Lr.No.D.Dis. **A/3171/90**

Sub: MMDA - Planning Permission - Construction  
of residential building in Plot No.45 part &  
46part at S.No.1/2 of Virugambakkam  
village - Approval - Reg.

The approved plans are numbered as Planning permit  
No. **A/926/90** and **3** copies/sets of the same along with the  
copy of the planning permit are enclosed herewith for taking  
further action in this regard.

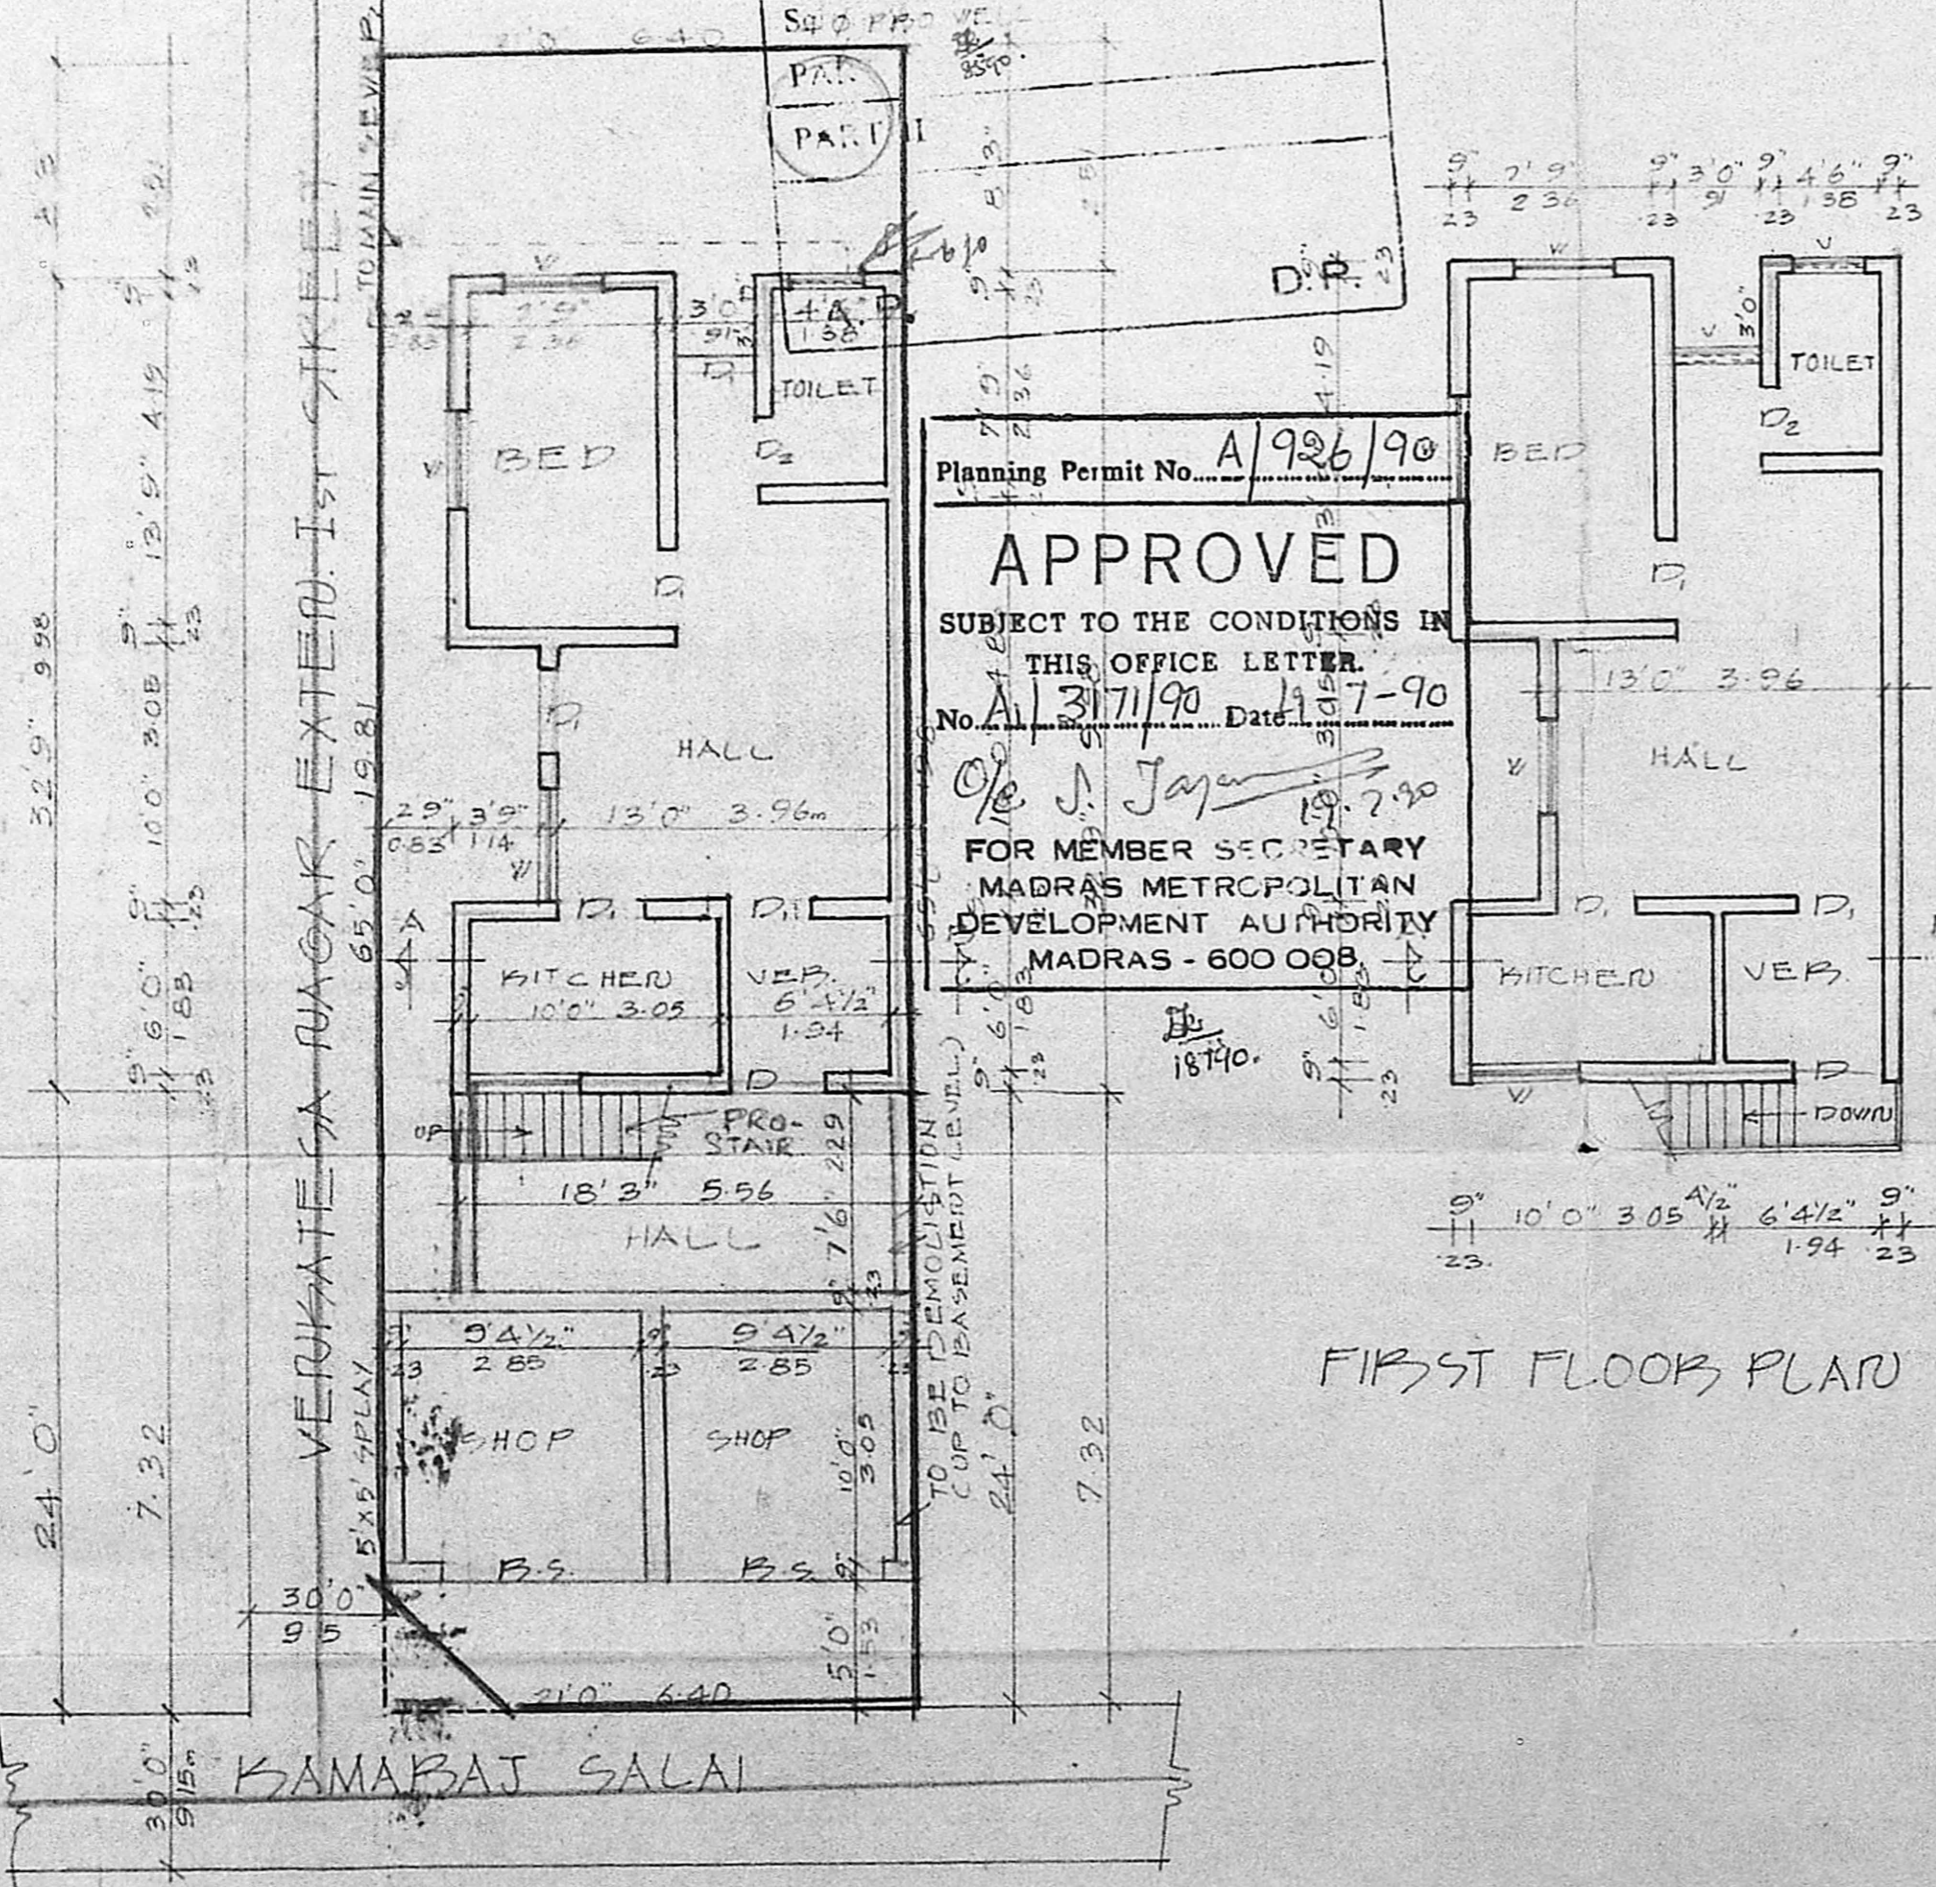
**You are requested to issue Building permit only after  
demolishing the portion shown as to be demolition in plan.**
